Our ref: Bullawah Wind Farm (SSD-50505215)

Subject: Request for Additional Information

I refer to the assessment for the Bullawah Wind Farm (SSD-50505215). After careful consideration, the Department requests the following additional information:

Figure 10 Right hand bend on Sturt Highway at Balranald – Option 2

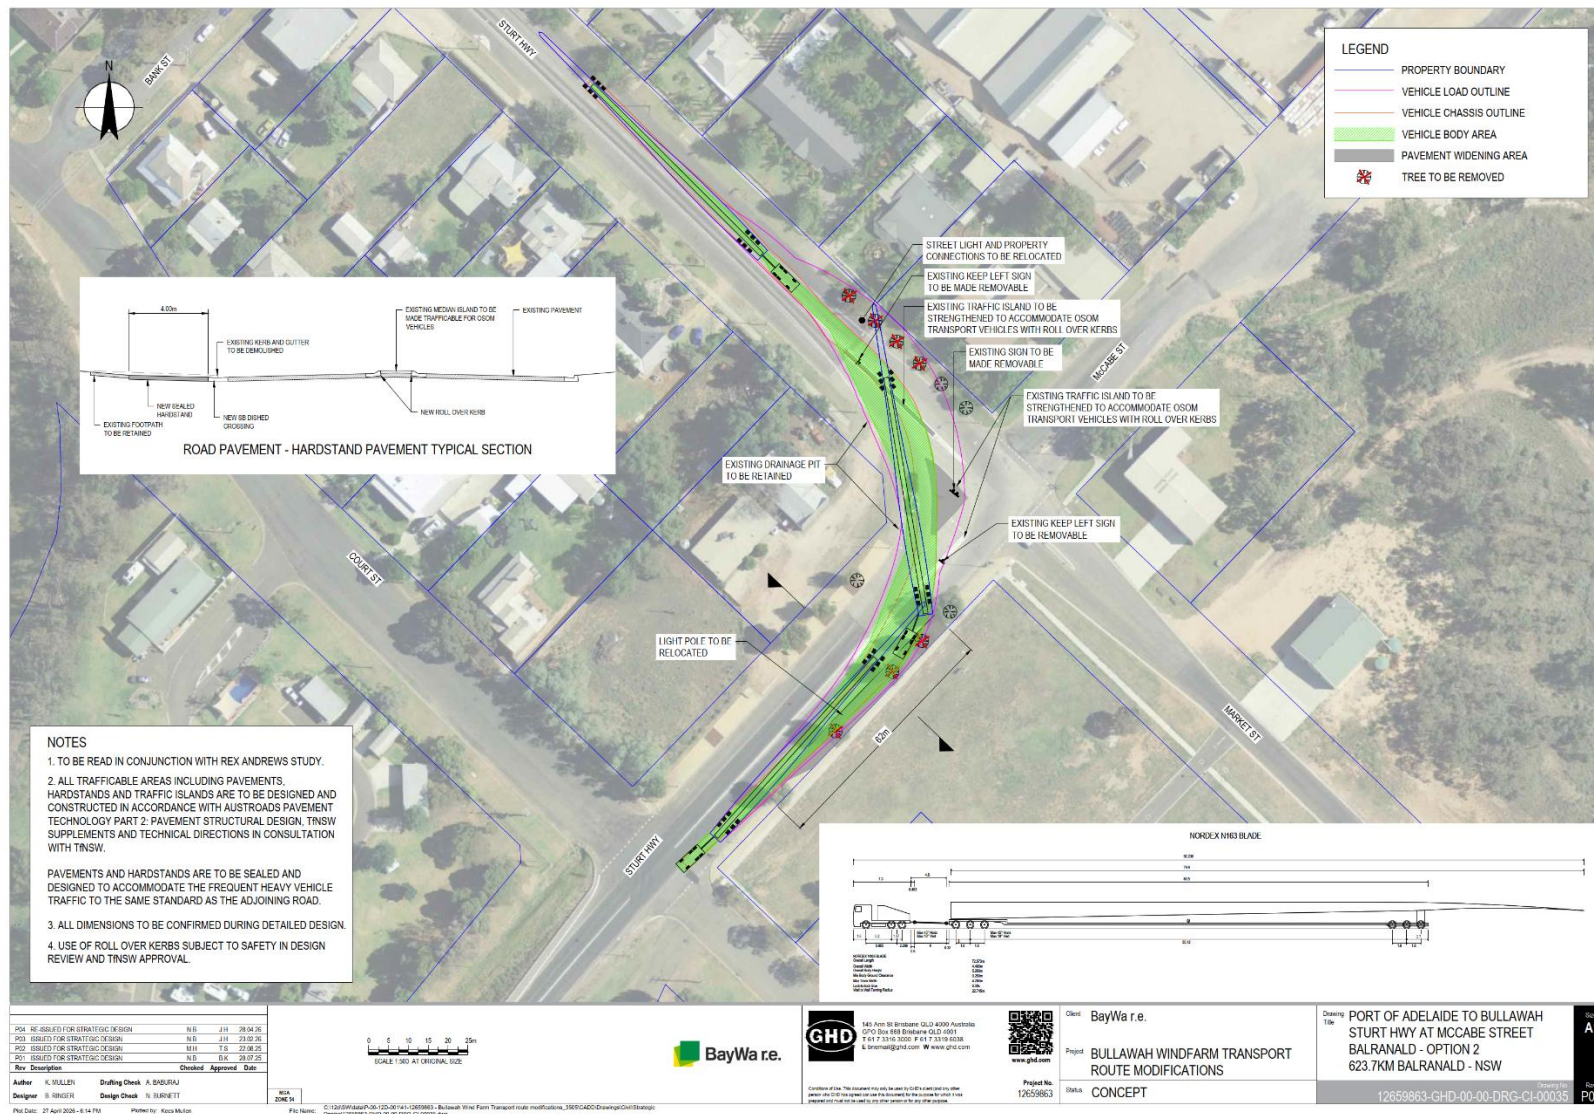
- Revised strategic designs for the road upgrades proposed at Euston and Balranald in accordance with comments provided from TfNSW and revisions to the design of the intersection at the Cobb Highway and Jerilderie Road to consider cumulative impacts;
- An amended project description including an updated consolidated table of road upgrades; and
- Updated information to verify the environmental assessment of the road upgrades, particularly in relation to the revisions to the intersection at the Cobb Highway and Jerilderie Road.
